CITY OF ALBUQUERQUE

November 14, 2023

Re: Dutch Bros. Coffee
2501 Juan Tabo Blvd. NE
30-Day Temporary Certificate of Occupancy
Transportation Development Final Inspection
Engineer's Stamp dated 11-17-22 (H21-D004B)
Certification dated 11-07-23

TRAFFIC CIRCULATION LAYOUT PLAN

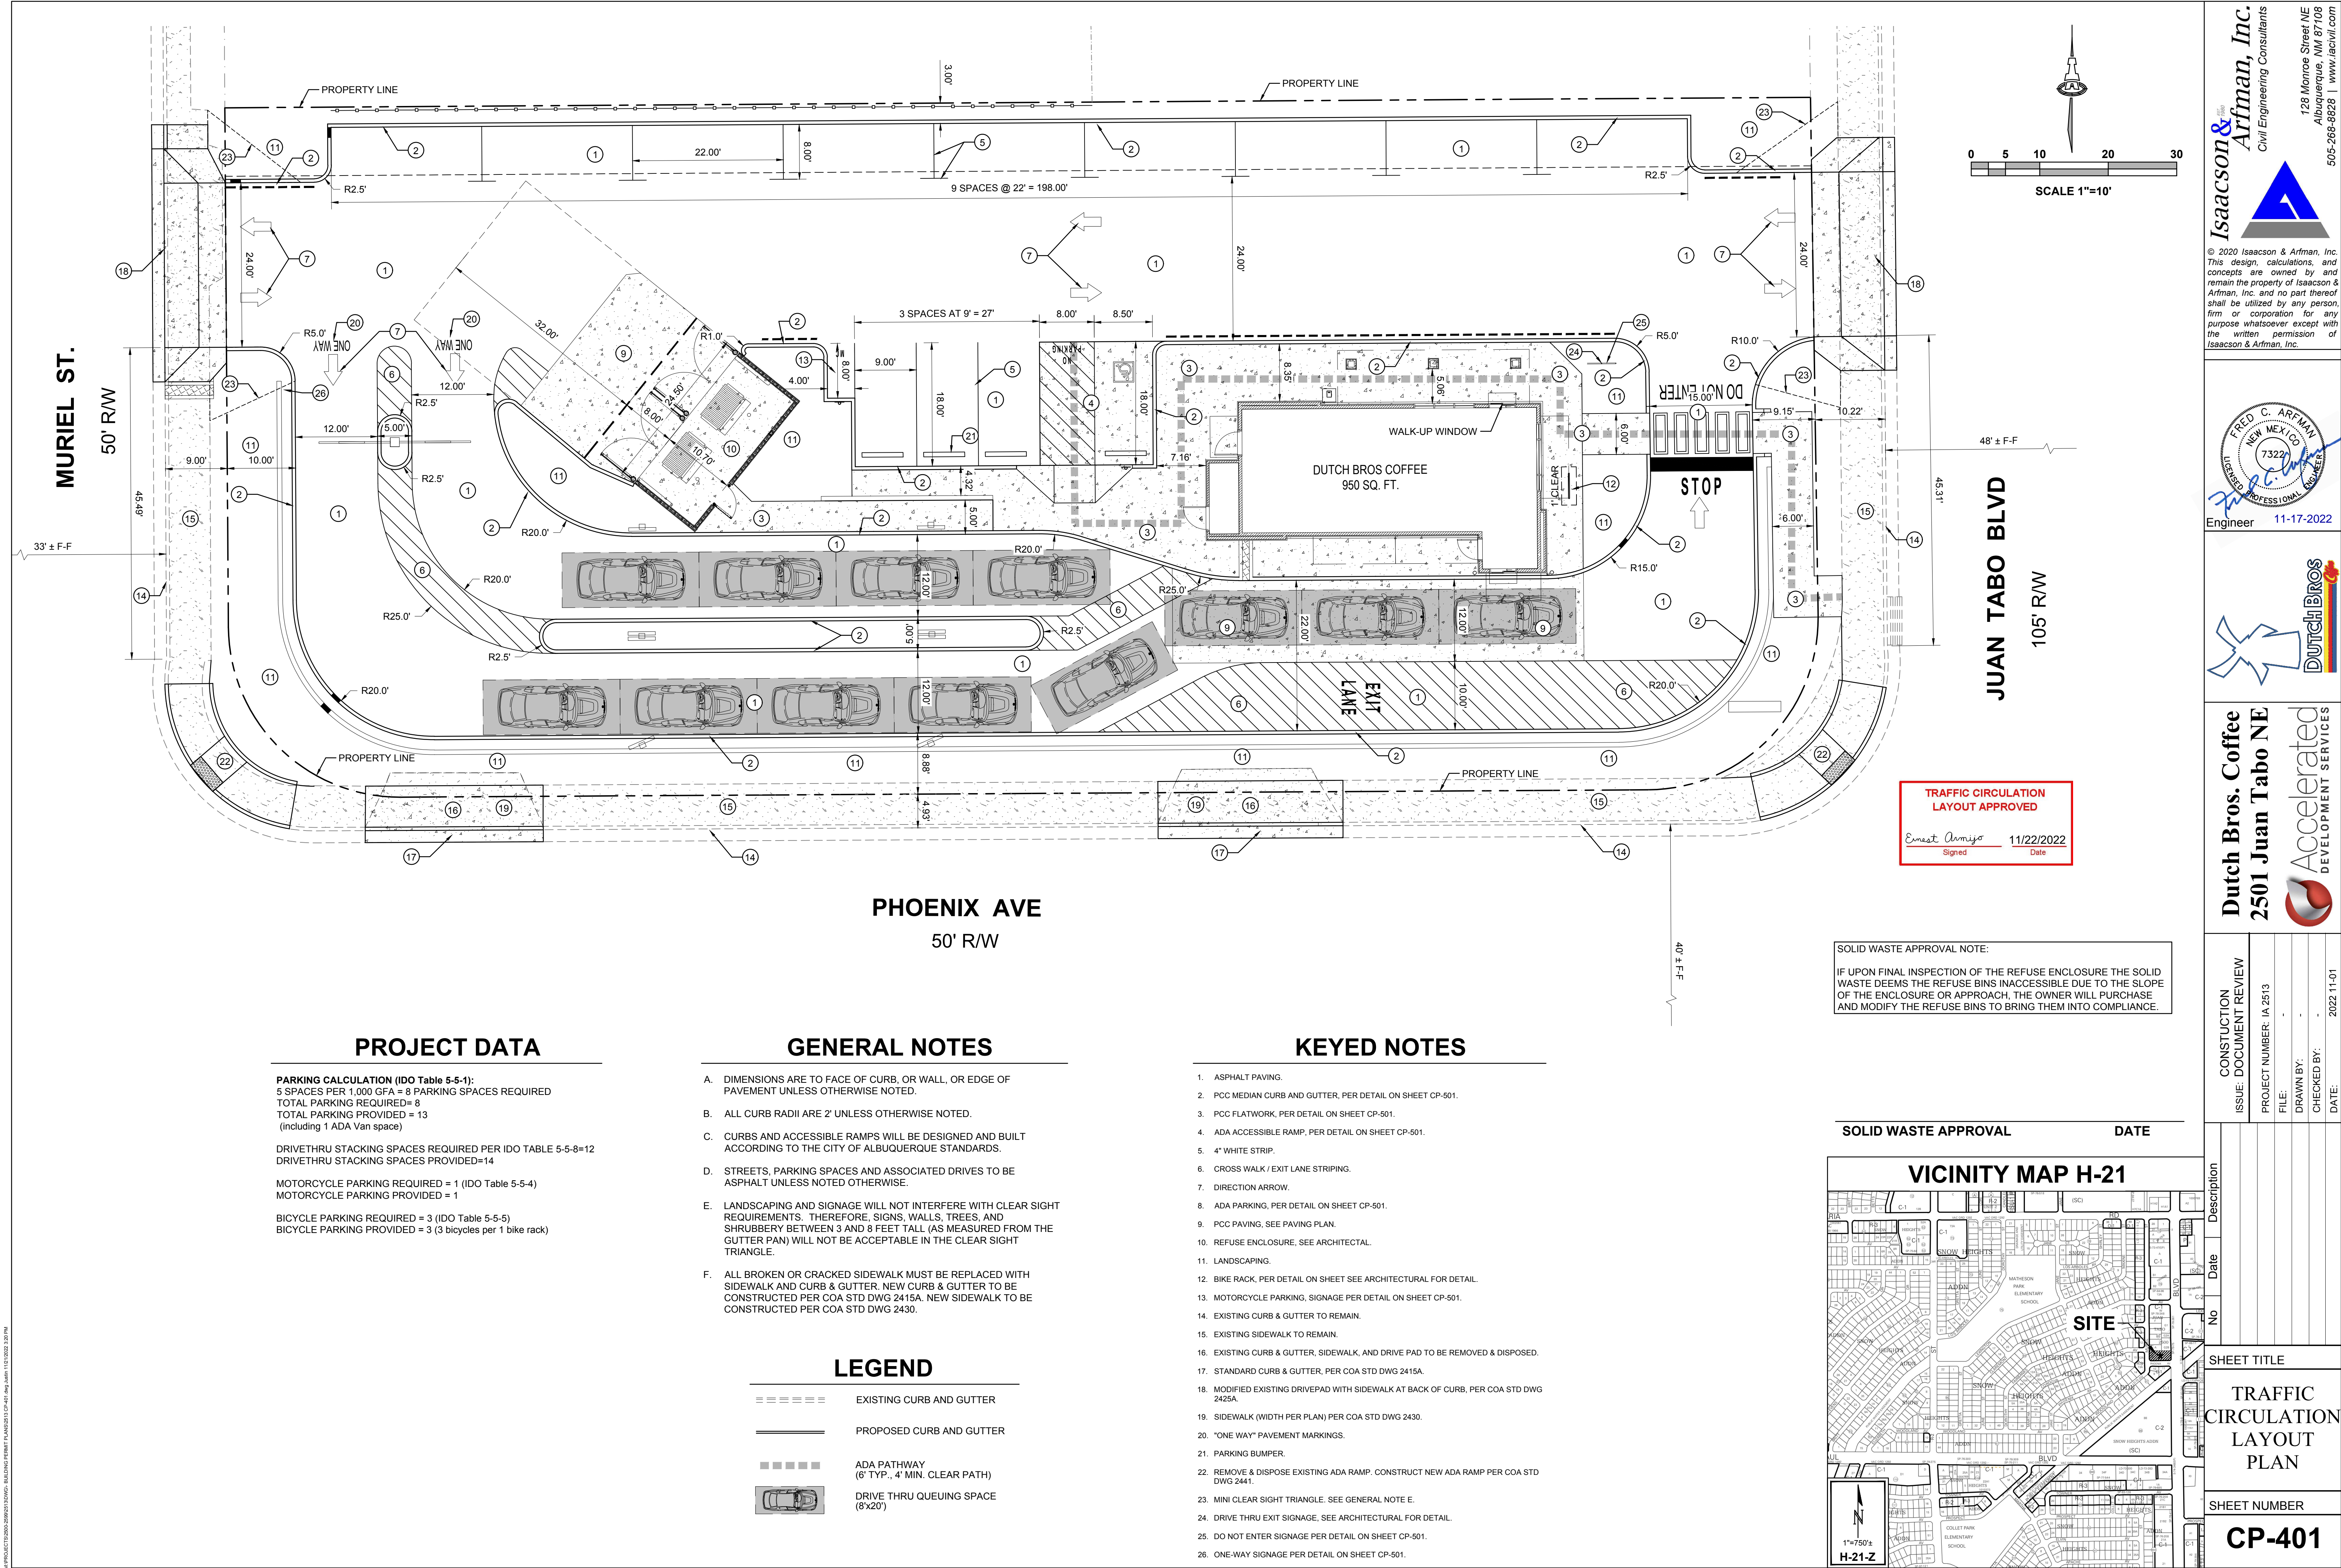
- Site access off Juan Tabo Blvd: Per city std the pedestrian pathway should be minimum 4 ft. wide. Per site visit the pathway was only 3 ft. wide. Please provide 4 ft. pathway.

- Per site visit, the new sidewalk off Phoenix Ave. has a cross slope range between 2.8% and 3.4%. Please note that maximum allowable cross slope should be 2%.
